My concerns are about the proposed new road scheme providing access to Huntingdon Railway Station and the associated car park area.

**STATION CAR PARK ACCESS
WORK NO. 36 - WORKS PLANS
SHEET NO. 29**

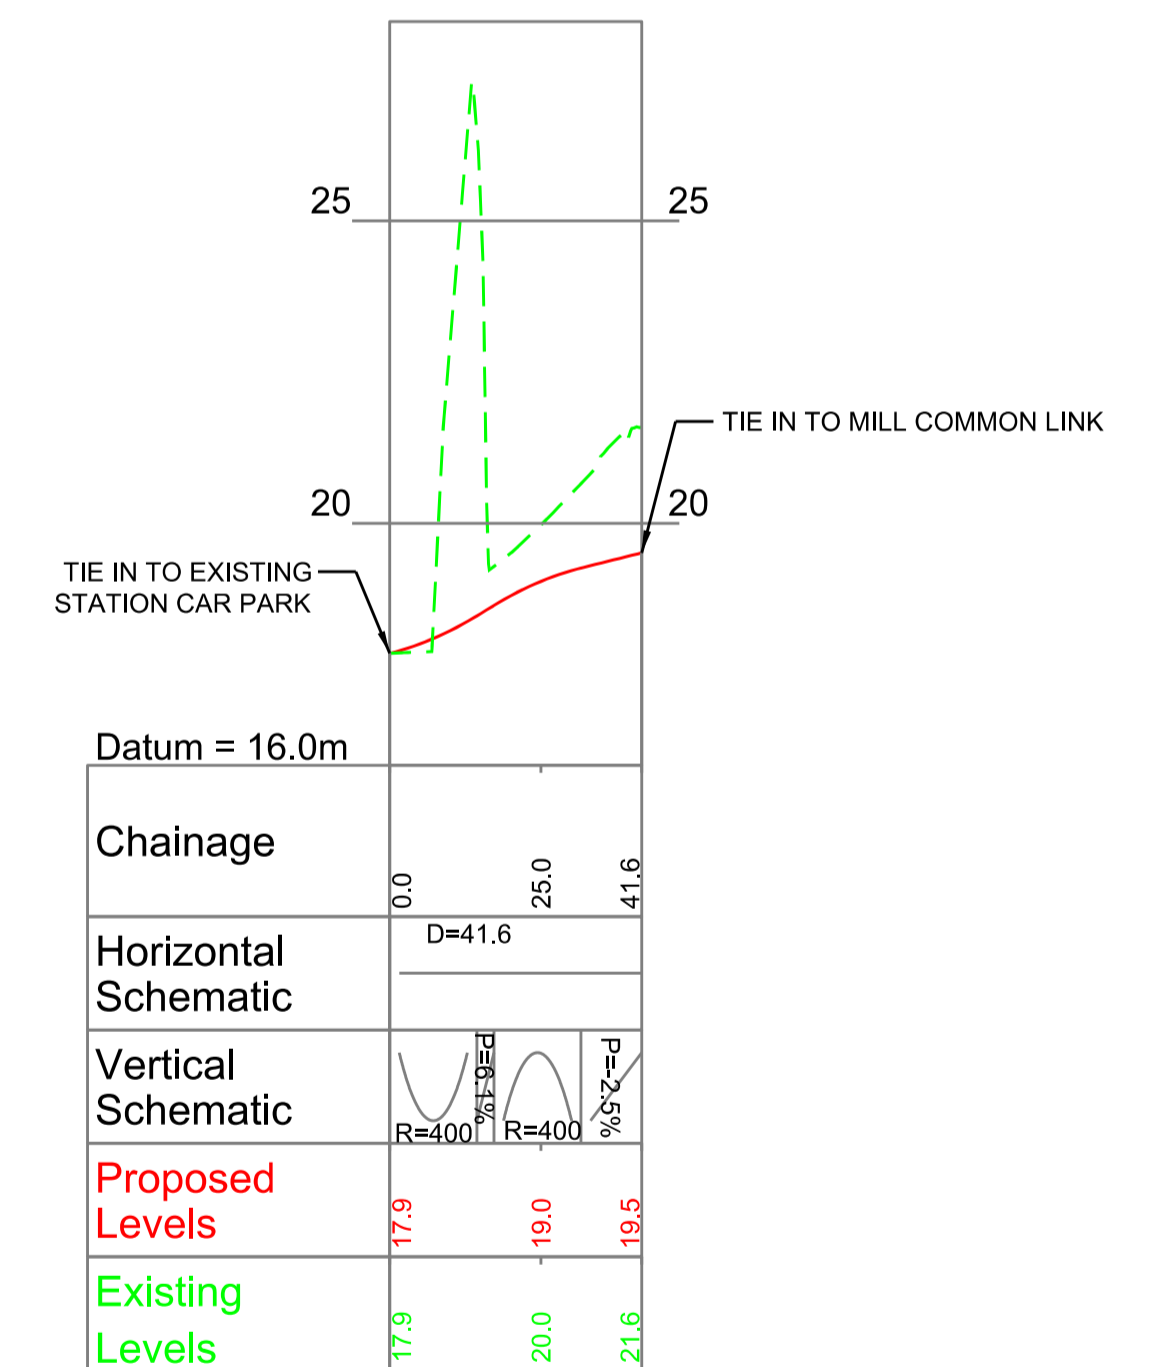
- i. the proximity of Station Cottages to the proposed new car park access road and to the A14
- ii. the necessity for substantial barriers between Station Cottages and both the proposed car park access road and a de-trunked A14 to mitigate the impact of noise, air and light pollution, and provide security for residents if the scheme proceeds.
